SCOTTISH POWER – EAST ANGLIA ONE NORTH AND EAST ANGLIA TWO

REFS – 20024254 & 20024255

EAST ANGLIA ONE NORTH OFFSHORE WINDFARM
EAST ANGLIA TWO OFFSHORE WINDFARM

CAH2: WRITTEN SUMMARY SUBMISSIONS ON BEHALF OF
MICHAEL MAHONY MOOR FARM, FRISTON

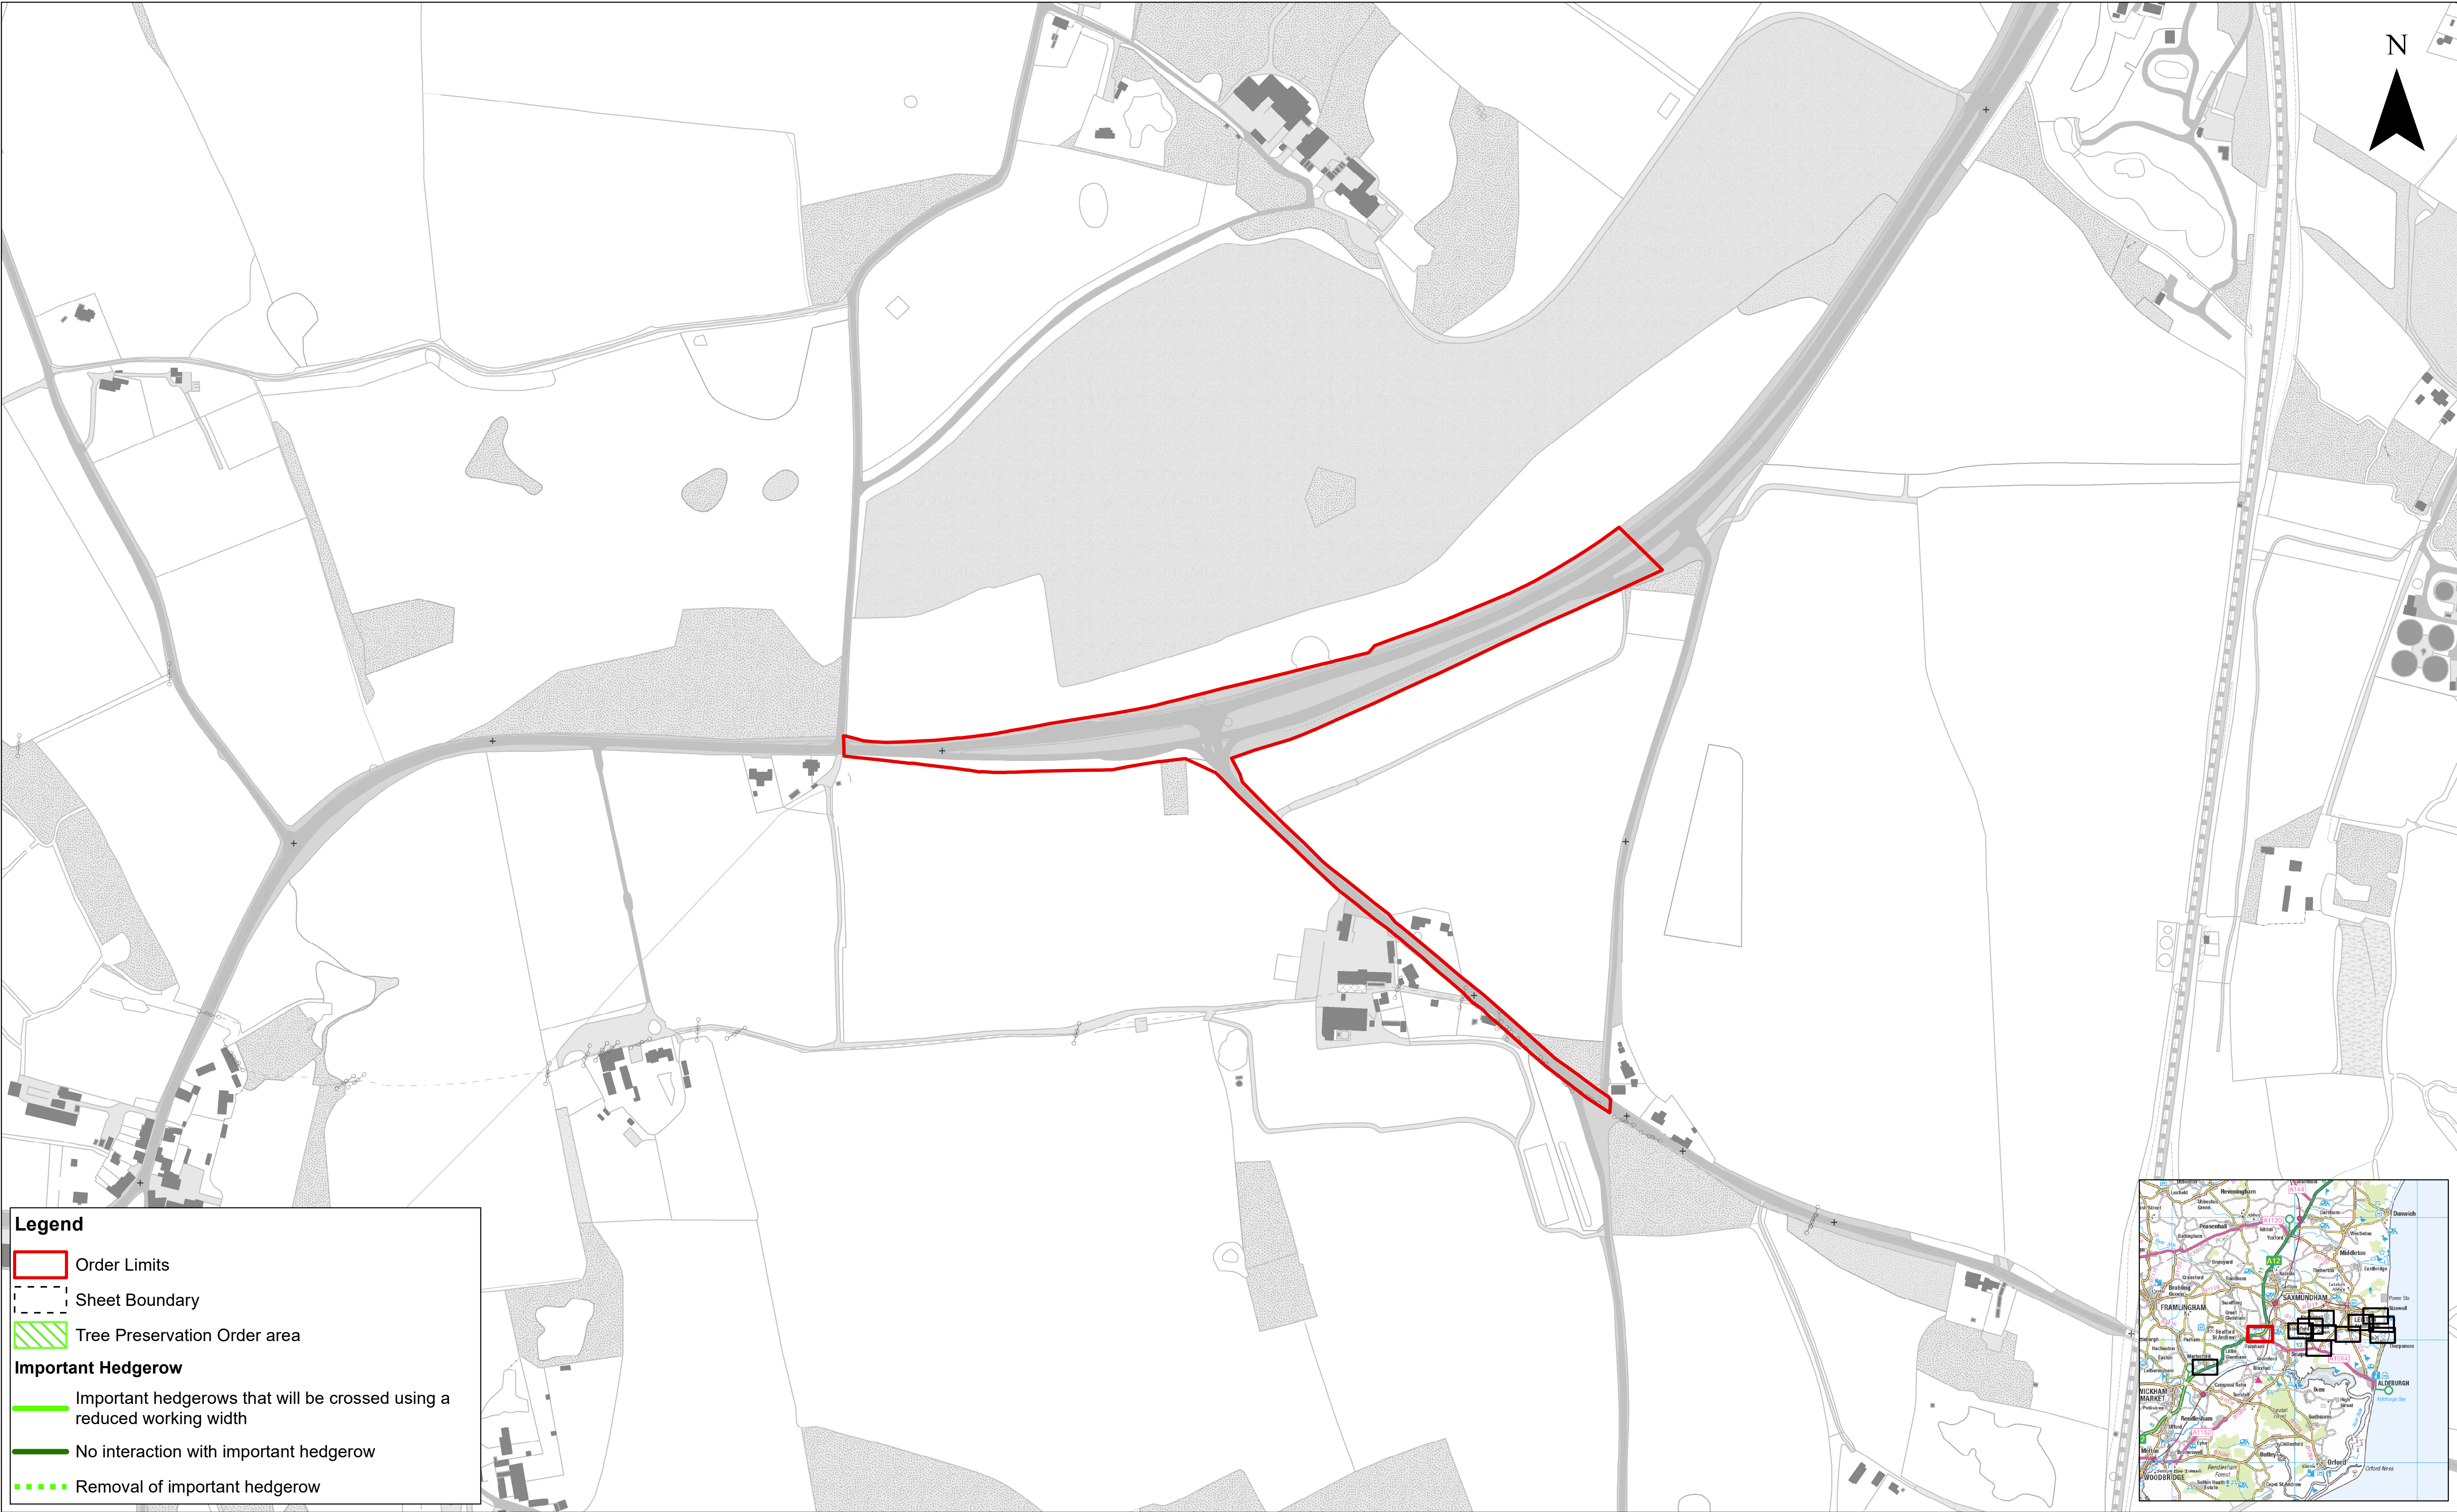
22. MM expressed concern about the effects of the proposed development on a number of the hedgerows present on his property. He drew attention to [APP-020, sheet 9] which shows those "*important*" hedgerows which the Applicant intends to remove in the vicinity of MM's property. He also noted the comments from East Suffolk Council [REP5-010, p.22, item 15] which question whether the removal of these hedges is justified.

23. MM adopts these concerns. However, he is also concerned about the possibility that other hedgerows (including those surrounding his land – including those adjacent to or within Plots 115, 116, 117, 117A 128 and 129) have been marked for removal but not necessarily deemed “important”. This would give rise to loss of privacy and potential ecological harm. MM agrees with the ExA [PD-031, p.19] that further information and clarification is required on this point.
24. Further, MM notes that Arts. 34-35 of the DCO do not include any requirement for the undertaker to provide advance notice of works to fell or lop trees. These provisions should be amended to include a stipulation that no such works may take place unless the undertaker has notified the landowner with notice in writing specifying the proposed works no less than 28 days in advance.
